**Our ref:** RA/2021/143906/01-L01  
**Your ref:** 2021/94280  
**Date:** 12 January 2022

**ERECTION OF 67 DWELLINGS WITH ASSOCIATED WORKS – LAND AT LADY ANN ROAD, SOOTHILL, BATLEY, WF17 0PY**

**Environment Agency position**

Drawing no: 10703-SELF-P-ZZ-A-M3- 001
Rev: N

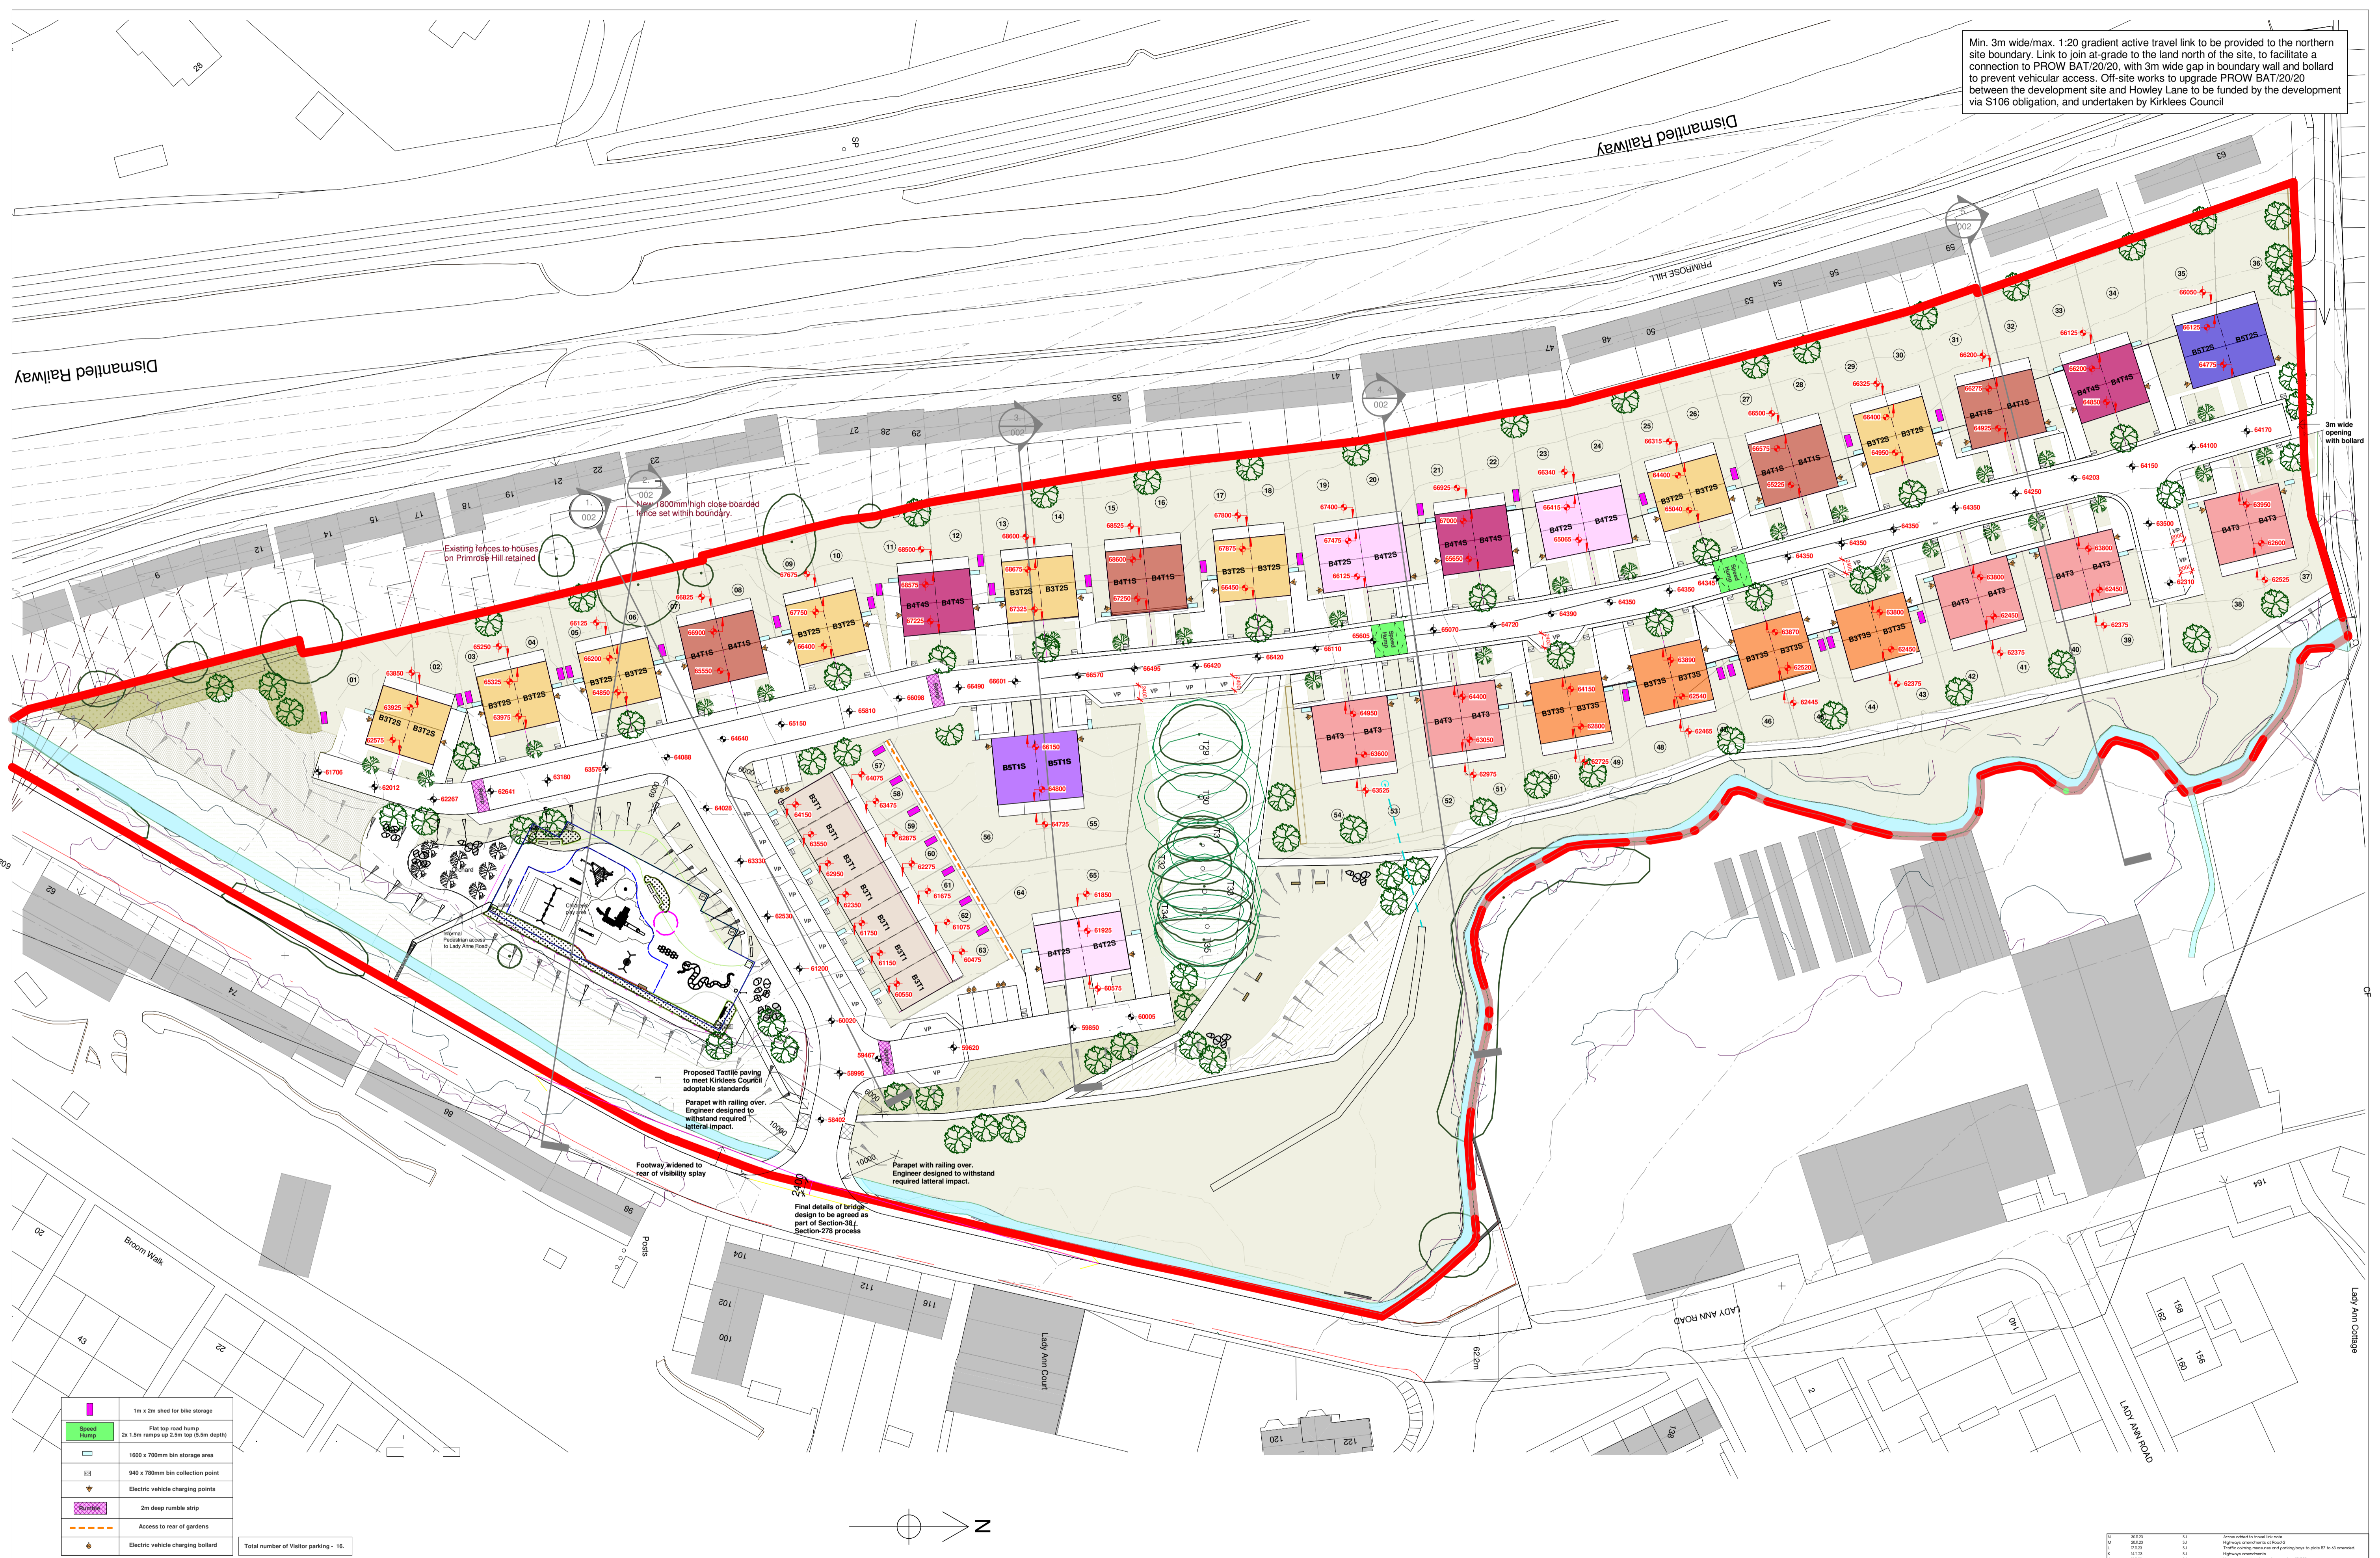
We understand that the number of properties with this current submission has reduced by 4, although the property numbering remains the same (ie plots 1-71), omitting plots 55, 56, 68 and 69, as detailed on the 'Proposed Site layout – drawing number 10703-SELF-P-XX-DR-A-002'. Appendix C in the FRA shows the site layout with the omitted properties still in situ. For reasons of clarity, the site layout in the FRA should be updated to reflect the latest position.

ANNEX 2: OVERLAY OF THE FLOOD MAP ON THE SITE LAYOUT PLAN 4026-102-U

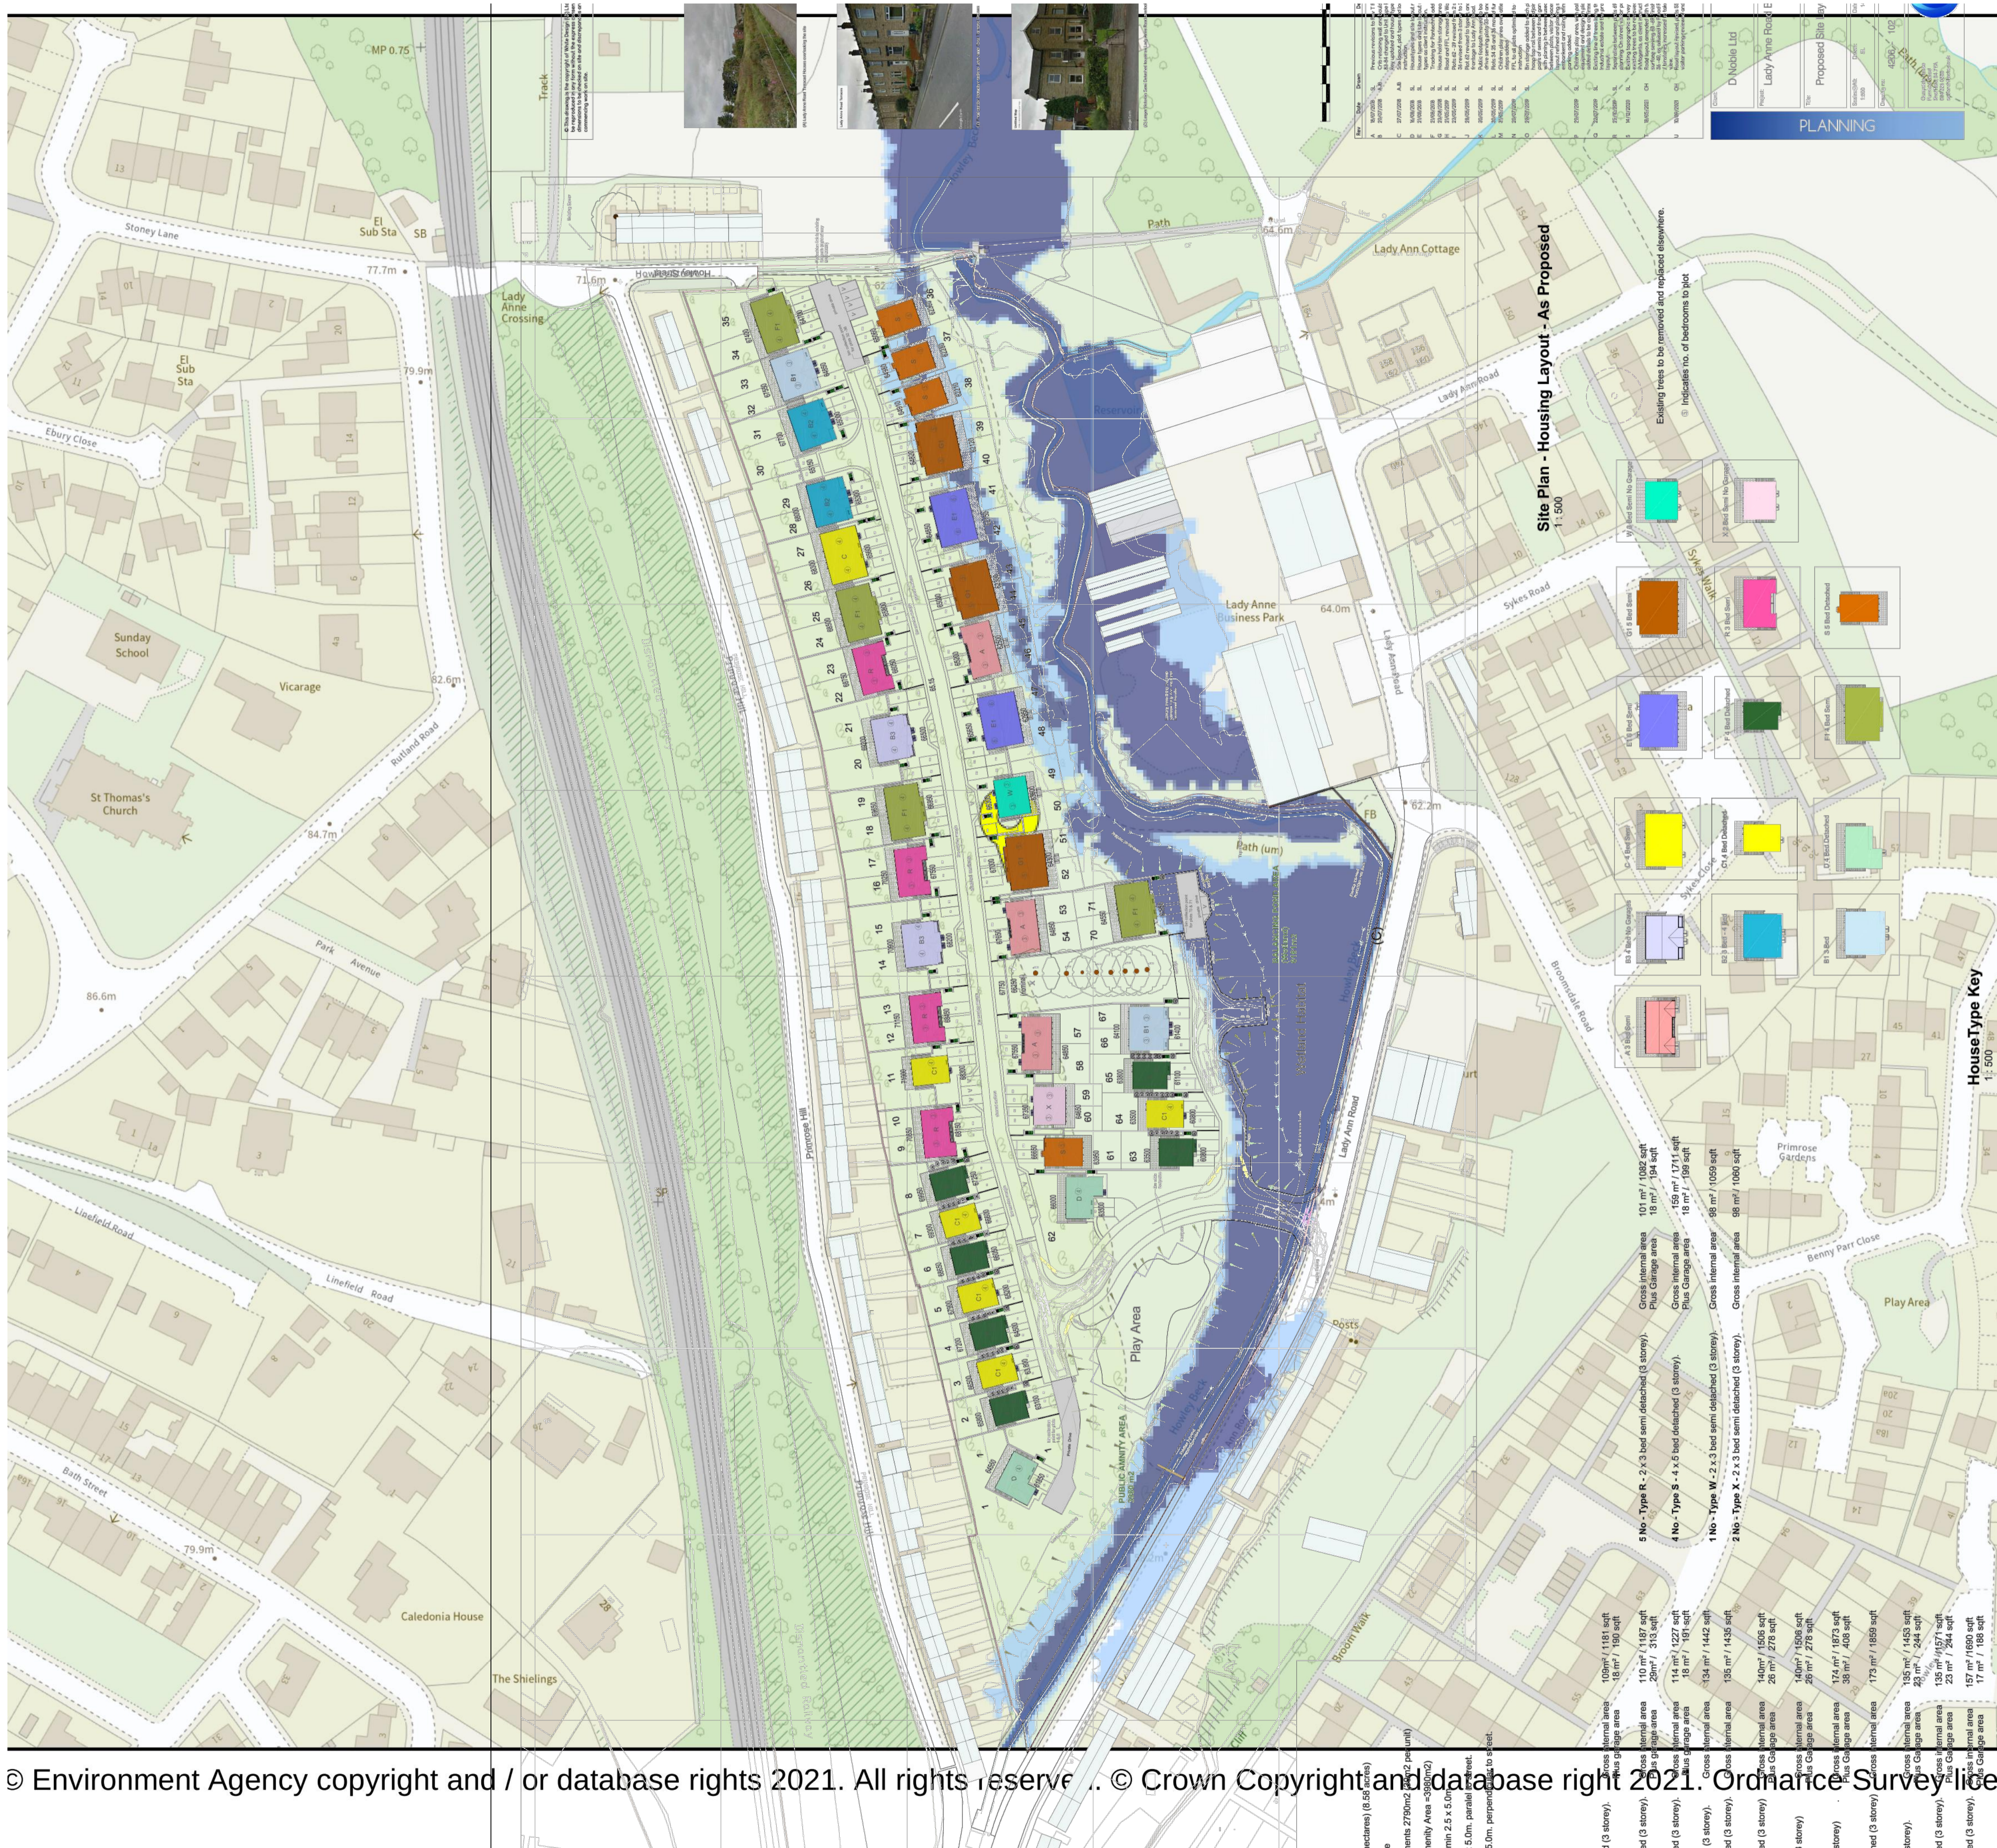
It appears that some of the remaining properties are within flood zone 3, again for clarity it would be helpful if the flood zones were overlaid onto the site plan to demonstrate whether this is the case.
